**SSD 9043 – 1-2 MURRAY
ROSE AVENUE, SYDNEY
OLYMPIC PARK**

**RESPONSE TO
DEPARTMENTS KEY ISSUES
ASSESSMENT**

3. APT 1.08.01

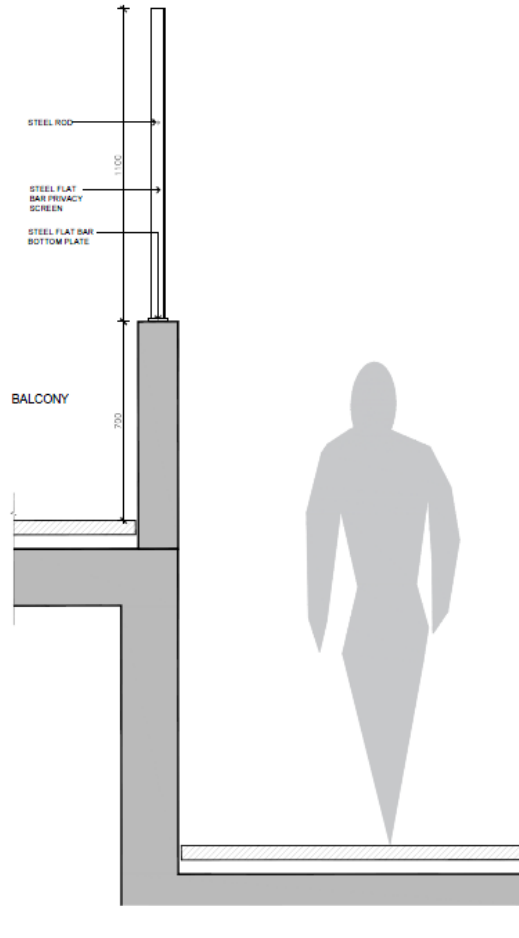
Issue	Comment	Response	Refer to
		<p>The furnished layout of bedroom apartment will provide essential amenity and ample space to move around the furniture to achieve individual comfort. Additionally a window is added to the living room, improving natural ventilation.</p> <p>Furthermore, given these are single-aspect apartment facing to the west, these 7 apartments are less desirable than most of the others in the development and will be provided at a lower price-point. It is noted the application still achieve's 70% solar & 60% cross ventilation compliance.</p>	
	Demonstrate how privacy and amenity would be achieved to the balcony/living areas of apartments 1.00.01, 1.00.02, 1.00.03, 1.00.10, 1.01 .03, 1.01.13, 1.01.14, 1.08.01, 2.00.01, 2.01 .01, 2.01 .02 and 2.01 .03. Consideration must also be given to the implication of any proposed privacy screens/landscaping on solar access to these apartments.	<p>Apartments 1.00.01, 1.00.02, 1.00.03, 1.00.10, 2.00.01, 2.01.01, 2.01.02 & 2.01.03:</p> <p>A vertical slatted fence is proposed to screen any direct overlooking. Additional planting increases the sense of privacy as well as softening the green edge. This is illustrated further in Appendix J.</p> <p>Apartments 1.01.13 & 1.01.14</p> <p>Where the balconies sit right along the boundary, the 1.8m high fence is proposed with 700mm high solid balustrade, which will prevent any privacy issues.</p> <p>Apartment 1.08.01</p> <p>A 2m high slatted fence is provided for this apartment.</p>	<p>Refer Appendix I & J.</p> <p>Refer to DA-10-2600 (B).</p>

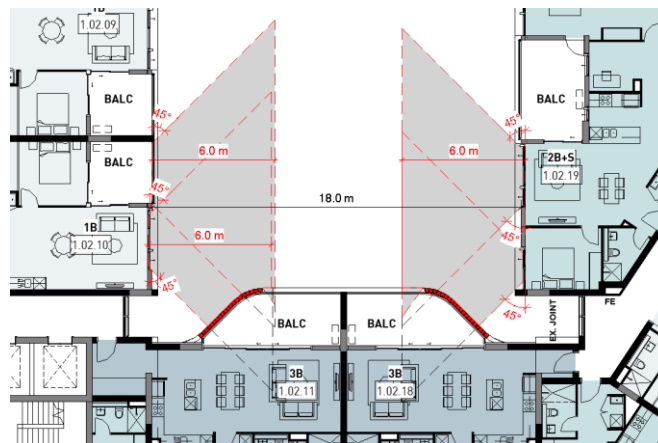
Provide further information and consideration regarding the proposed privacy mitigation measures and lines of sight between the balconies serving apartments 1.02.11	A vertical louvre is provided on the balcony to ensure additional privacy to 1.02.11 & 1.02.18 (and the identical apartments above).	Refer Appendix I and DA-10-2200 B.

Updated Architectural Plan DA-10-1900 & DA-10-4900

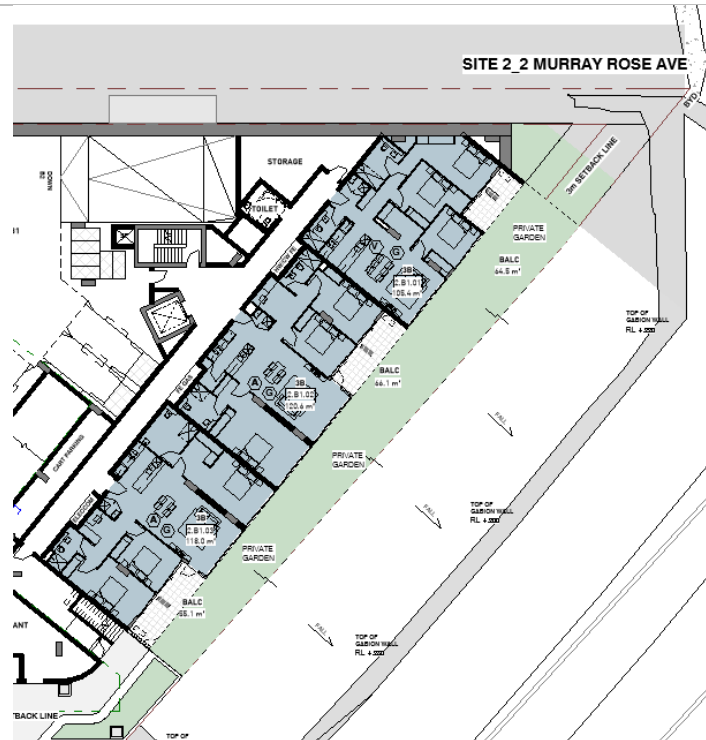
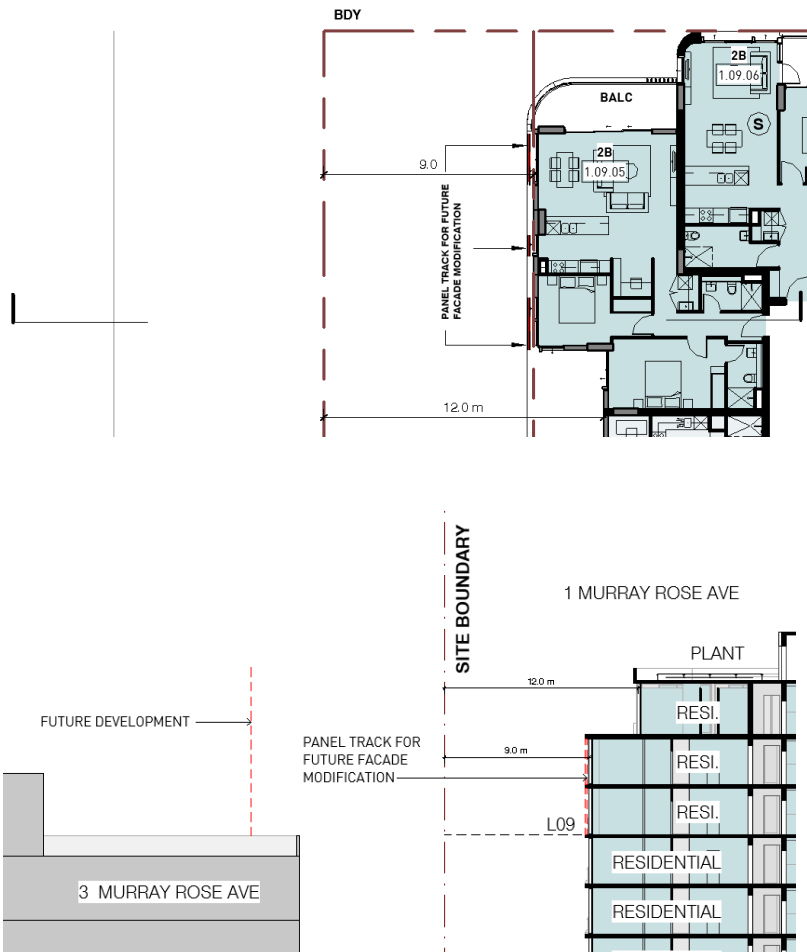
Issue	Comment	Response	Refer to
	and 1.02.18 (and the identical apartments above), and the habitable rooms and balconies of units 1.02.10 and 1.02.19 (and the identical apartments above).		
	Confirm why apartments 1.07.13 and 1.07.14 are identified as cross-ventilated in drawing 94- 000.	<p>Apartments 1.07.13 and 1.07.14 are not cross-ventilated.</p> <p>Refer to updated DA-94-0000 (Cross Ventilation Compliance Diagram), showing overall 60% compliance.</p>	DA-94-0000 B.
	Provide plans demonstrating compliance with ADG minimum storage volume recommendations (including provision of a minimum of 50% within the apartment).	Please refer to Appendix R of this report for a breakdown of storage area for sites 1 & 2. This demonstrates compliance with the ADG.	Refer Appendix R.
	Provide revised plans demonstrating deep soil area calculations and clearly identifying areas that satisfy the ADG 6 m minimum dimension recommendation. It also appears the deep soil area illustrated on drawing L0.01 includes the area occupied by balconies on the eastern side of both proposed buildings, as shown on the architectural plans.	<p>Note: The proposal has a total deep soil provision of 10%</p> <p>Site 1: 6.8%</p> <p>Site 2: 15.8%</p> <p>This is generally in compliance with the ADG control of 7%.</p> <p>The deep soil areas of also both achieve the 6m minimum dimension of the ADG.</p>	Refer Appendix J.
